**Re: Westpointe Data Center at 8401 Daytona Rd. NW
Erosion and Sediment Control Plan
Engineer's Stamp Date – 7/25/24 (K09E026D)**

Based on the information in your submittal, received on 8/29/24, the above-referenced ESC Plan cannot be approved until the following comments are addressed.

SHEET NO. ESC - 002

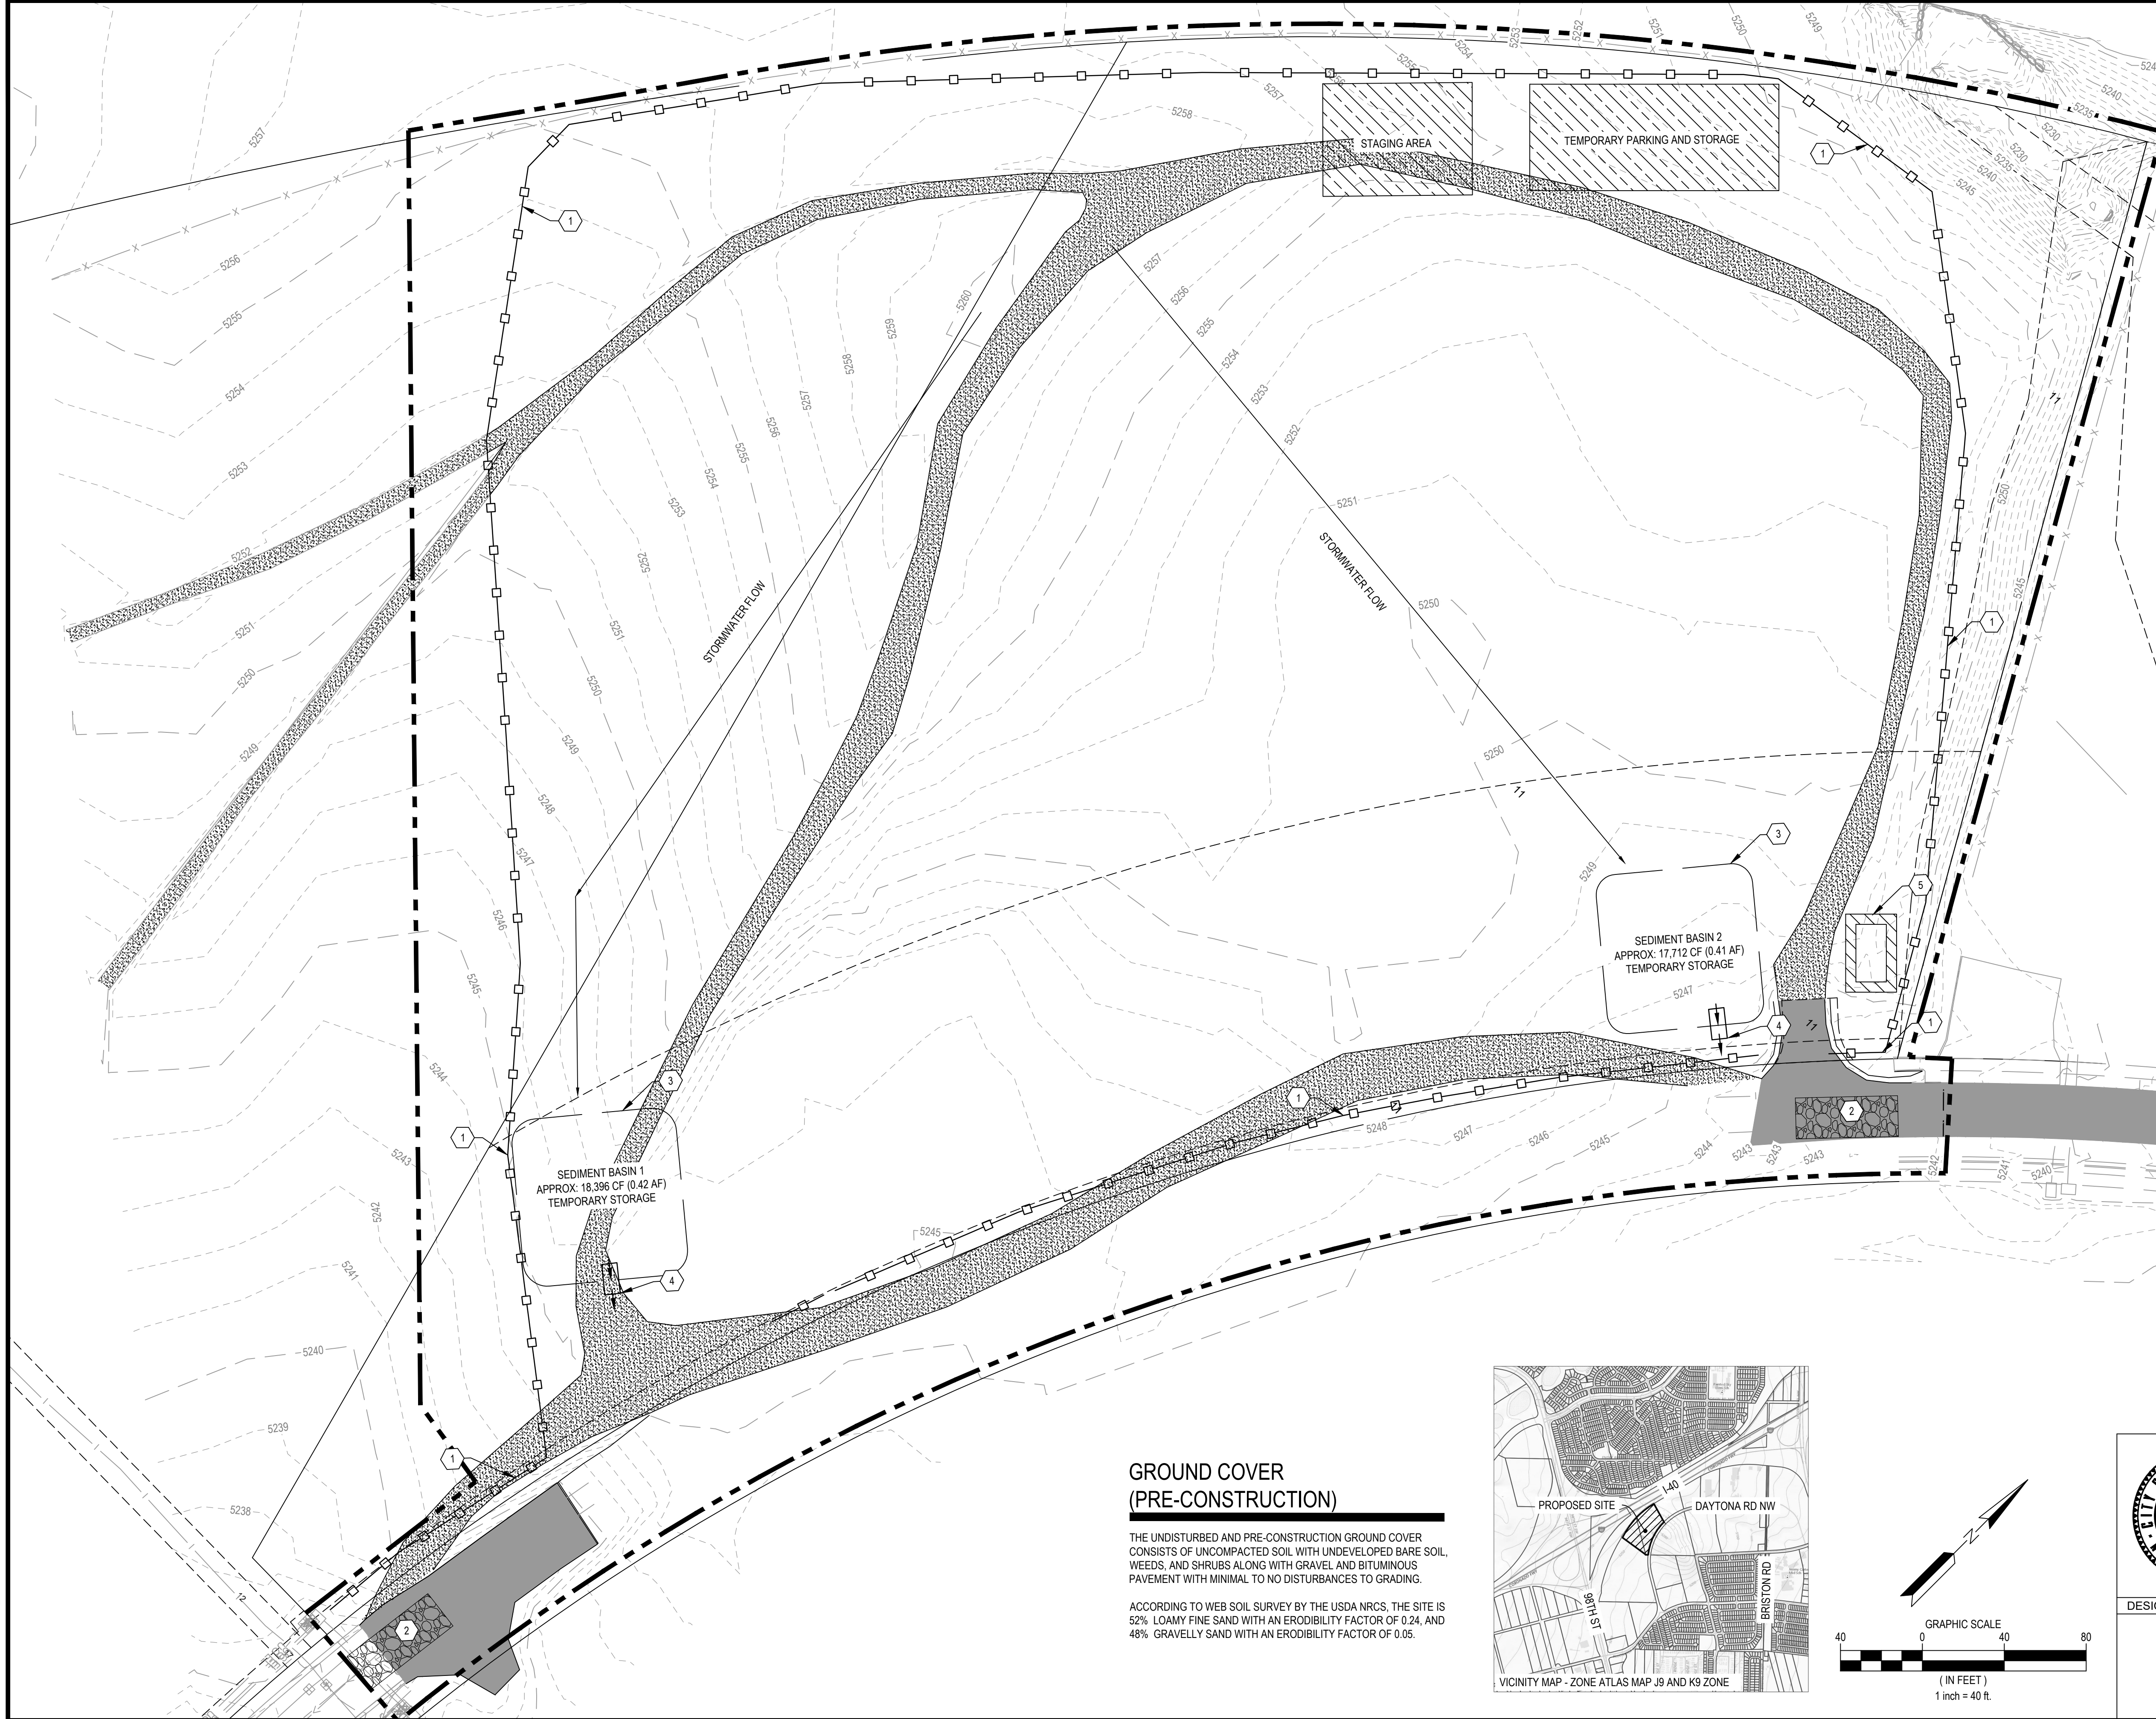
7. Move the concrete washout away from the drainage path in the low, east corner of the site. Add washout details and construction specifications.
8. Change the inlet protection detail to eliminate any screens inside the inlet or blocking the openings. Use sandbags placed on the edge of the street, the outside 4' of the street, upstream of the inlet.

SHEET NO. ESC - 003

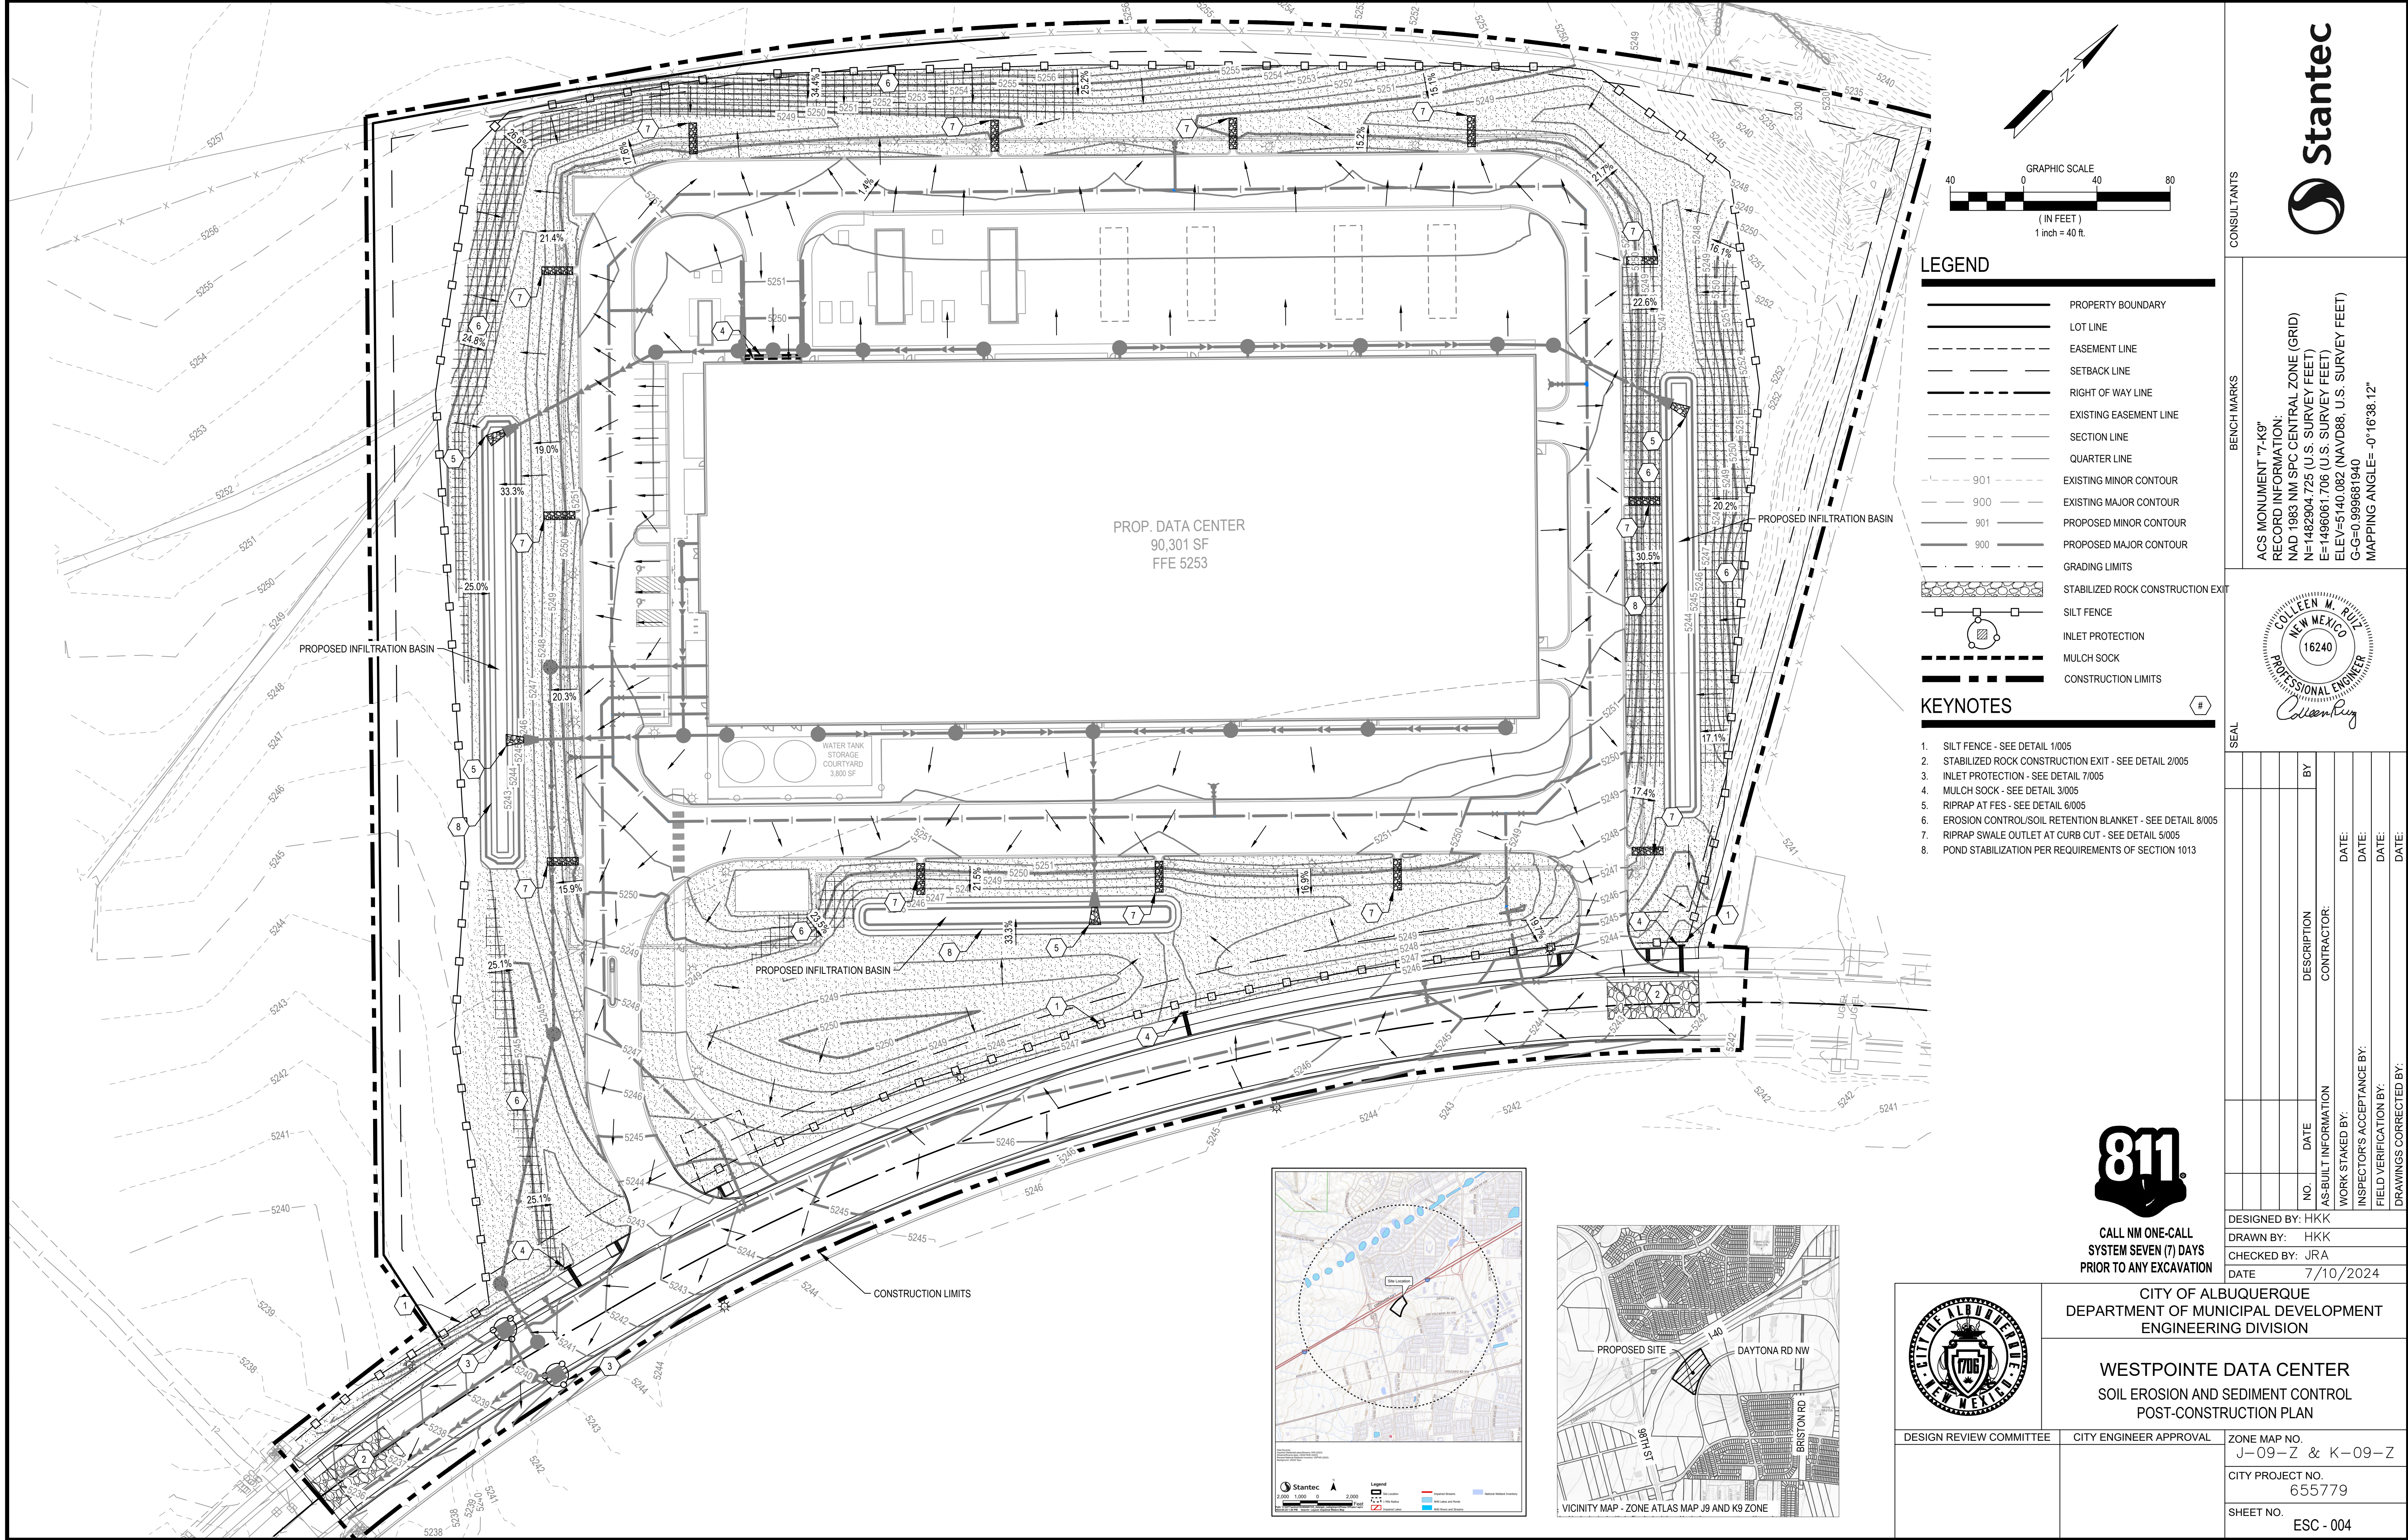
3. The ESC Plan seems to be missing. There is a Pre-Construction Plan, sheet ESC-003, and a Post-Construction Plan, sheet ESC-04, but neither sheet shows all of the required information in one view to identify conflicts. The ESC Plan must show the improvements together with the stormwater controls, and the stormwater controls (ponds, berms, & silt-fence) shouldn't be located where structures (buildings, sidewalks, & parking lots) will be constructed since the controls won't be removed until the rest of the site is stabilized. Show the controls and improvements together on a sheet called the ESC Construction Plan, including contours, property lines, and limits of disturbance without the heavy hatch patterns.

6. Temporary diversion berms or swales must be used along the southwest and northeast edges of the limits of disturbance to direct the stormwater into the sediment basins. Silt-fence alone isn't adequate but should still be on top or outside the berms and sediment basins. Add berm locations on the plan and details with dimensions and compaction specifications.

8  
002 SOIL RETENTION BLANKET INSTALLATION  
NOT TO SCALE

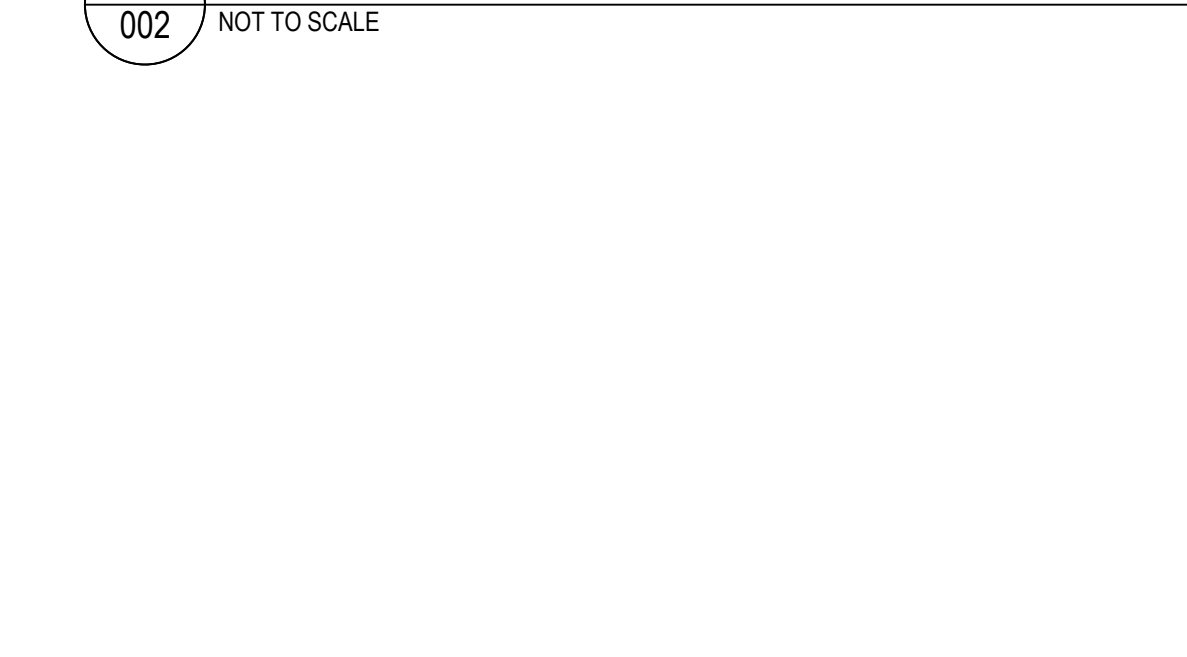
4. The Erosion Control Retention Blanket shown on the Post-Construction Plan, Sheet ESC-004, and the details on sheet ESC-005 are inconsistent with the details of the Landscape Plan, Sheet L-101, with LS Stamp date 6/3/2024. The SWPPP must include site-specific interim and permanent stabilization construction specifications per CGP 9.6.1.c.i. The Landscape Plan and Work Order sheets can be used to satisfy this requirement and should be submitted separate from the ESC Plan with the application to the Stormwater Quality Section of the Planning Department and they should be included in the SWPPP. Provide a specification on the ESC Plan for any disturbed areas not covered by the Landscape Plan or Work Order sheets.
